From: Erin Moore
Sent: Friday, September 13, 2013 8:13 AM
To: Jeff Watson
Subject: RE: BL-13-00017 Berger

[BL-13-00017 Berger](#)

RECORD OF SURVEY
PORTIONS OF THE NE 1/4 OF SEC. 35 & THE NW 1/4 OF SEC. 36,
TOWNSHIP 20 NORTH, RANGE 14 EAST, W.M.,
KITITAS COUNTY, WASHINGTON

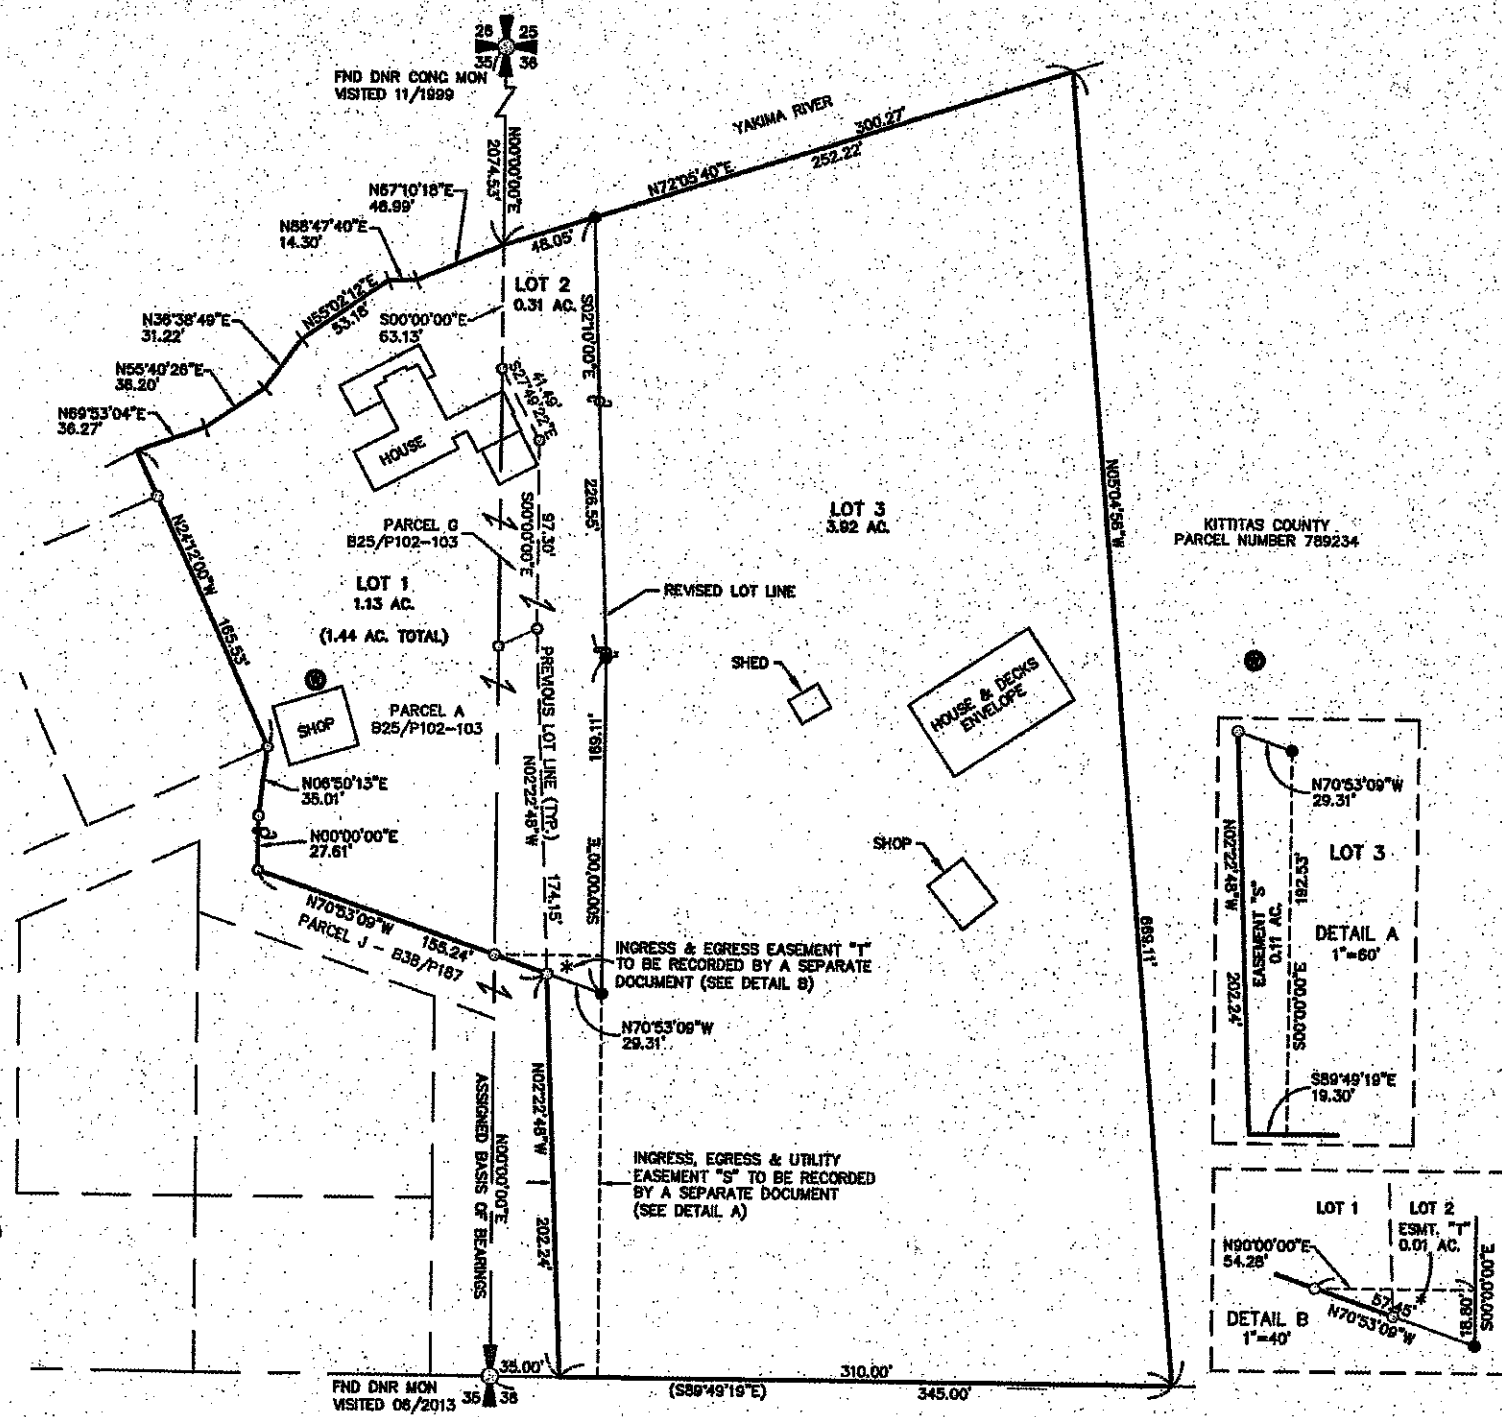
I could have sworn I sent this to you. We need to know where the well is (are) on this one.
